KIRKLEES METROPOLITAN COUNCIL INVESTMENT & REGENERATION SERVICE

DELEGATED DECISION TO DETERMINE APPLICATIONS FOR CONSENT, AGREEMENT OR APPROVAL REQUIRED BY CONDITION

Reference No:	2022/44/93001/W
Site Address:	Upper Hagg Farm, Upper Hagg Road, Thongsbridge, Holmfirth, HD9 6NJ
Description:	Discharge of Conditions 8 (materials), 9 (FFL's of agricultural building), 11 (passing place), 12 (bin store), 13 (surface improvements), 14 (phase 1), 15 (phase 2), 16 (phase 3), 19 (charging points) & 20 (boundary details) on previous permission 2021/93766 for demolition of existing buildings, removal of slurry pit, erection of agricultural building, partial demolition and alterations to existing buildings to form 3 dwellings, amendments to the existing access track, parking, landscaping and boundary treatments
Recommending Officer:	John Holmes

Passing Place Layout - 1:200

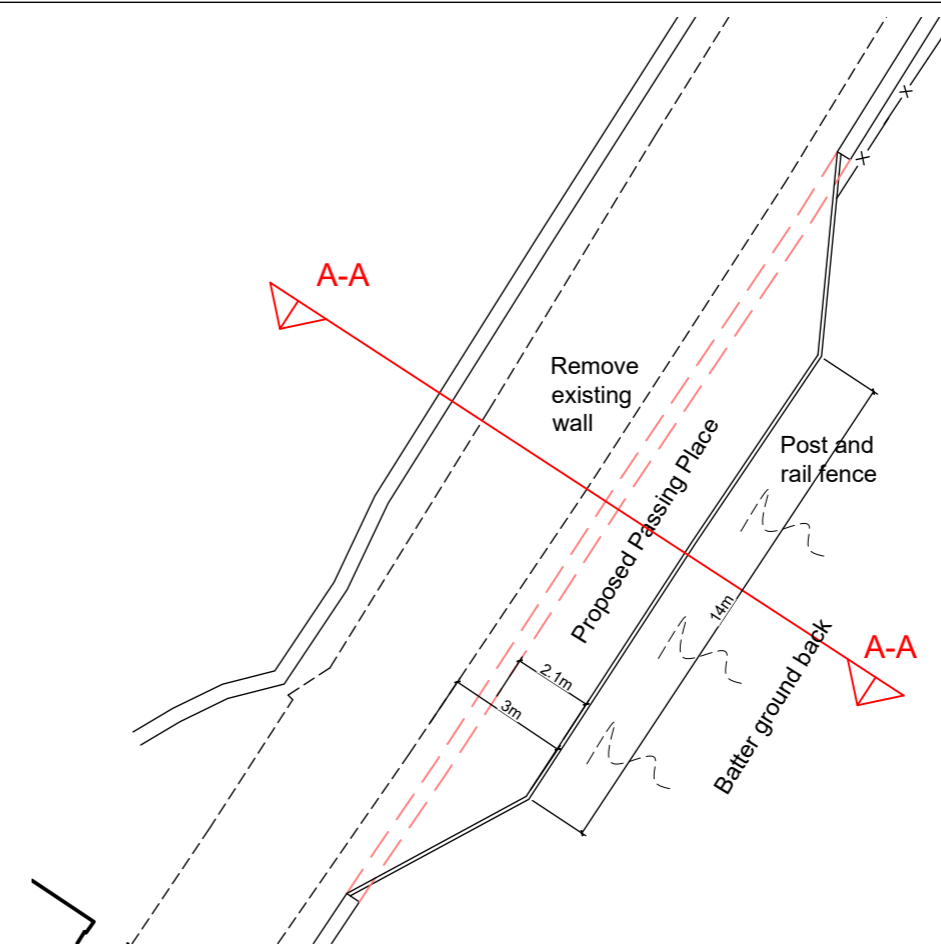
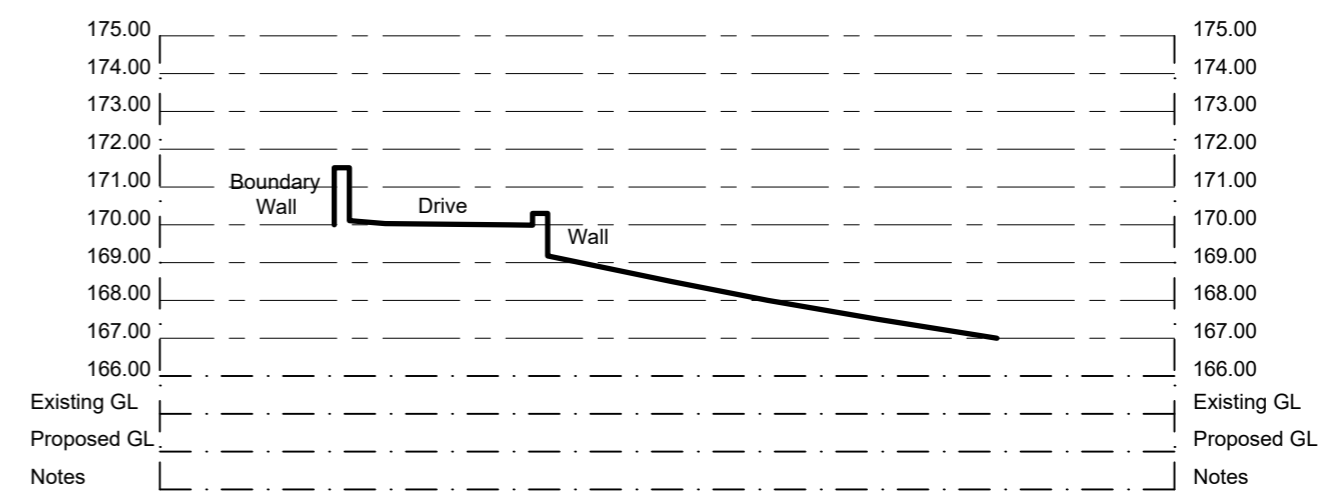
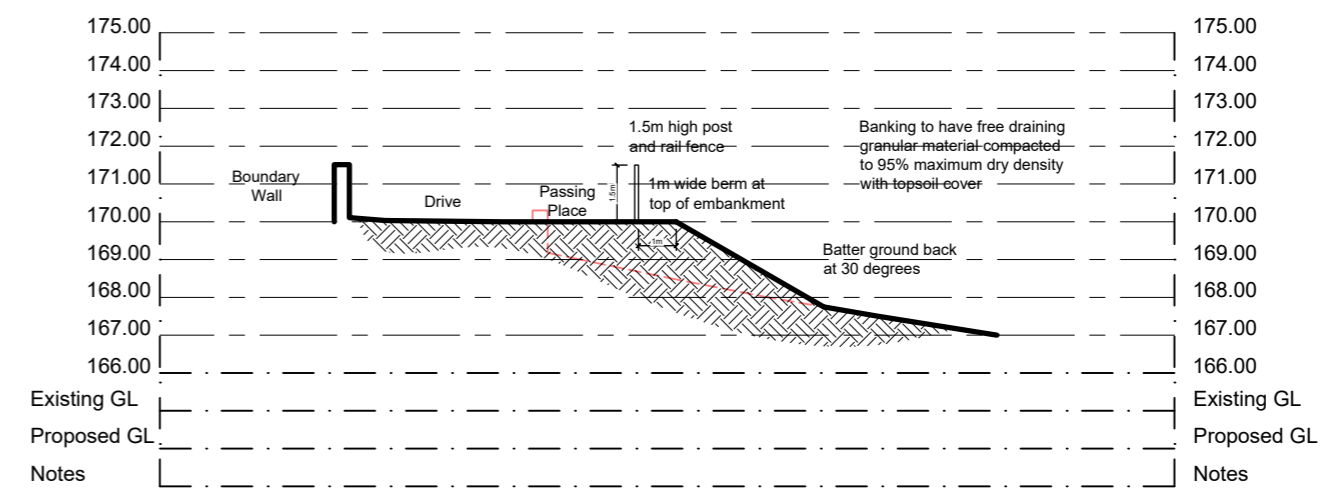
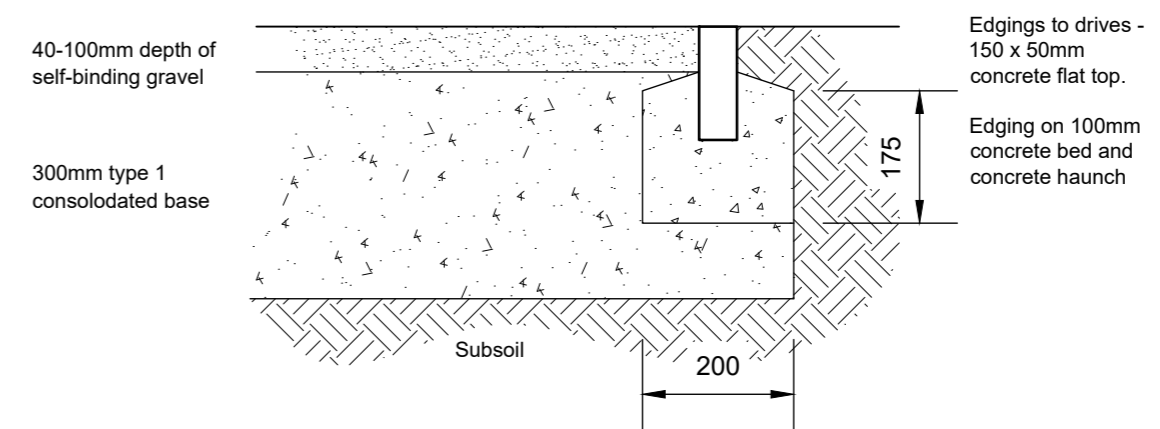
The submitted details show the location of the passing place and how it would be provided, through the removal of the existing wall and infilling of part of the land slope to enable a level passing place to be provided. An existing and proposed section is provided as part of the submitted scheme and details of the surfacing are also provided (40-100mm depth of self binding gravel above 300mm type 1 consolidated base material). Edging material is set out as as

being a concrete edging material at the same height as the proposed gravel, and concreted into place.

It is considered that the proposed passing place is in a logical location and would provide the necessary improvement required by this condition, the materials of construction being permeable are considered to be suitable in relation to surface water drainage. The submitted scheme is therefore considered to satisfy the requirements of this condition and meet the requirements of Policies LP21 and LP22 of the Kirklees Local Plan, Principles 12 and 19 of the Council's adopted Housebuilders Design Guide, Policy 11 of the Holme Valley Neighbourhood Development Plan, the Council's adopted Highways Design Guide and Government guidance contained within Chapter 9 of the National Planning Policy Framework.

Surfacing to be provided would be 40-100mm depth of self binding gravel above 300mm type 1 consolidated base material. Edging material is set out as being a concrete edging material at the same height as the proposed gravel, and concreted into place.

The extent of the surfacing be indicated upon drawing 104revP02 which sets out that the surfacing is for the full extent of the private access.
